Date: 07/05/2019
Our ref: /17379215v2
Your ref:

Re. outline application for up to 28 no. dwellings on land at The Boweries, Barnham Road, Eastergate, PO20 3RT (ref. EG/22/19/OUT)

scale 1:250 @ A3 date OCTOBER 2019 drawing number MBSK191001-01	title VISIBILITY SPLAYS AT ACCESS	client DOMUSEA DEVELOPMENTS project THE BOWERIES, BARNHAM ROAD EASTERGATE	drawn by JME checked by AP cad file FIGURES A.DWG rev. D
---	-----------------------------------	---	---

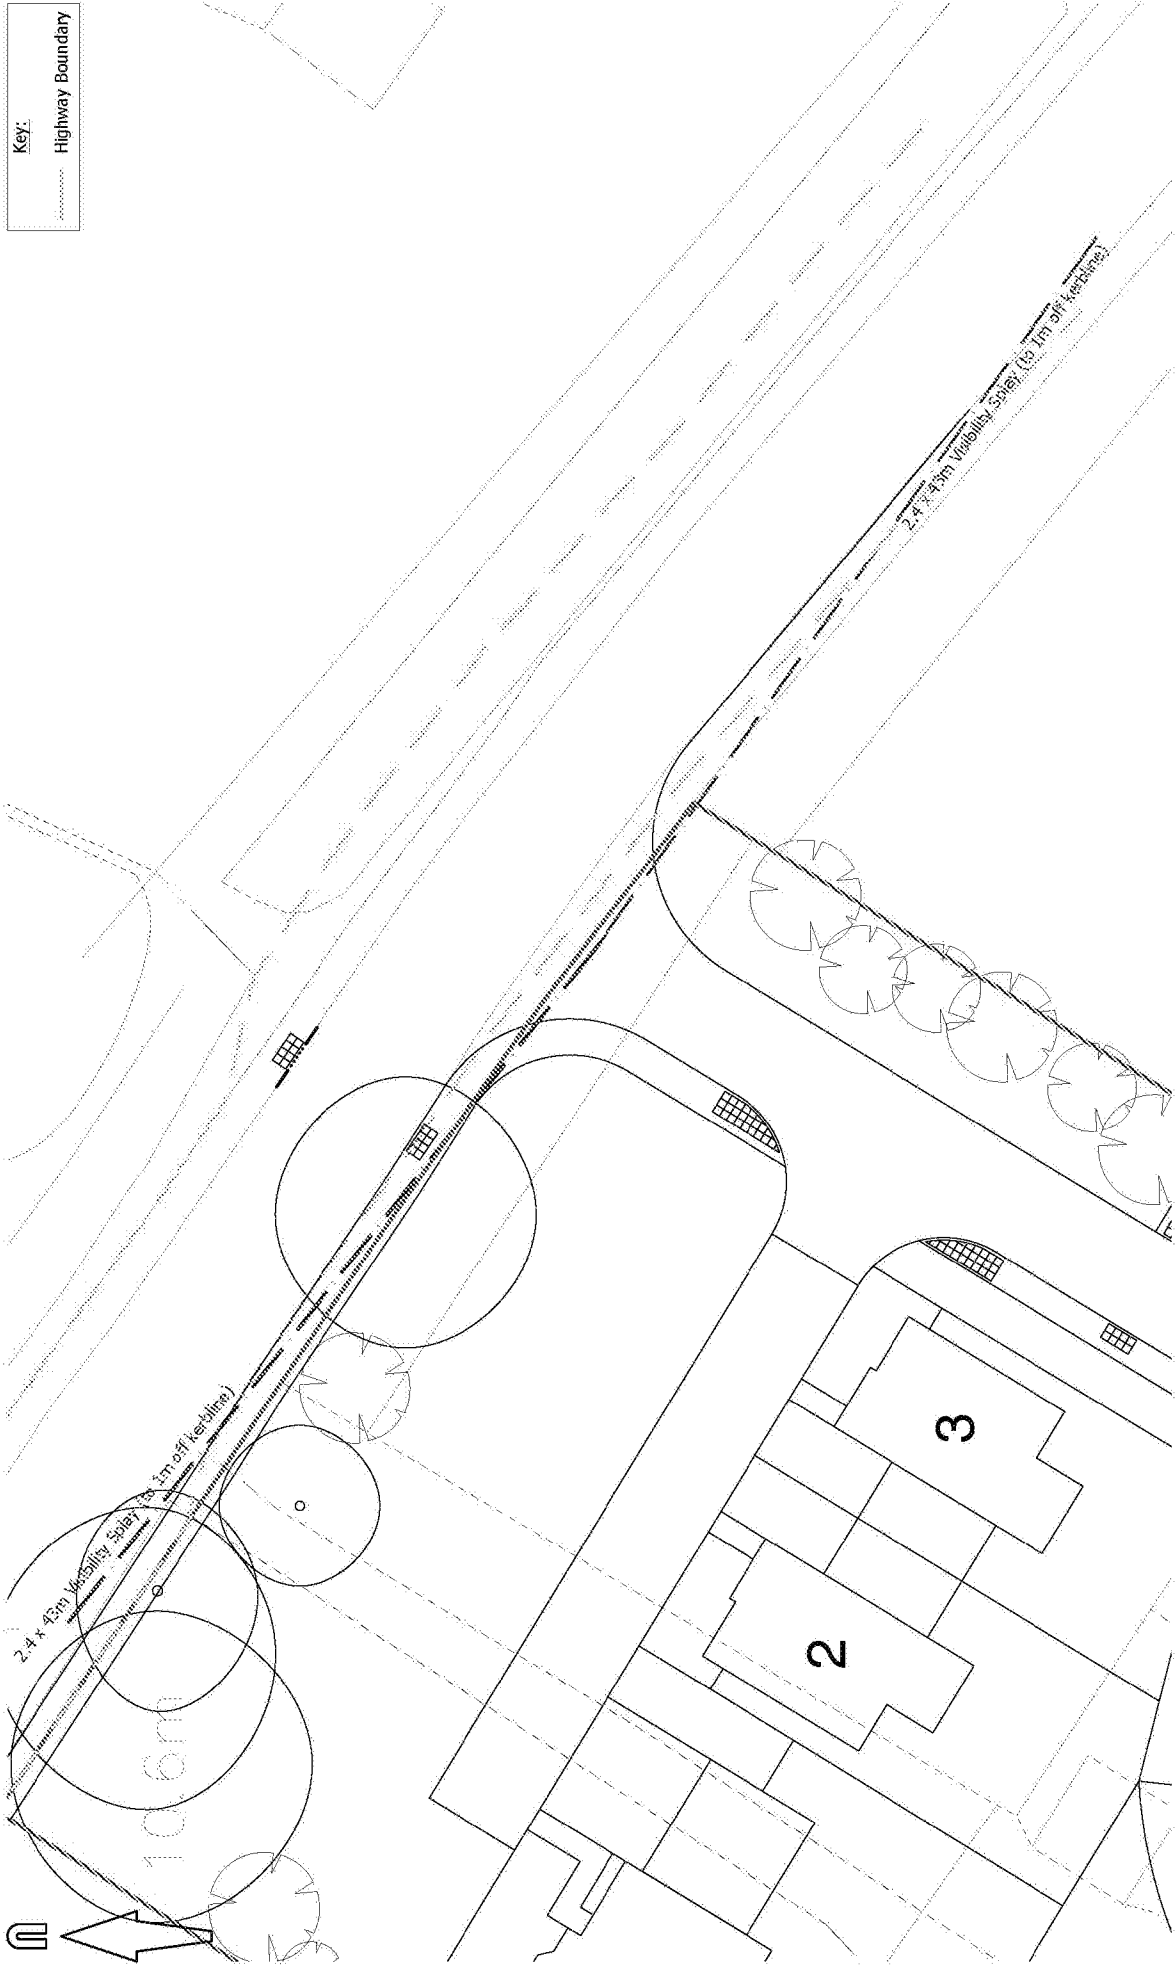
- 5 As noted previously, we remain unconvinced that the required visibility splays of 2.4m x 43m can be provided on the Barnham Road access; that all footways meet Manual for Streets guidance in terms of dimensions; that the strategic Westergate cycle link along the southern boundary of the site can be accommodated as required by Policy H SP2c SD5 (part g(v)); or that there are adequate vehicle turning opportunities throughout the site, particularly to the south. As access arrangements are a detailed matter, it is important that this is given due consideration at this stage, particularly to ensure that opportunities are not missed to connect the allocation and the wider area through vehicular, cycle and pedestrian routes.
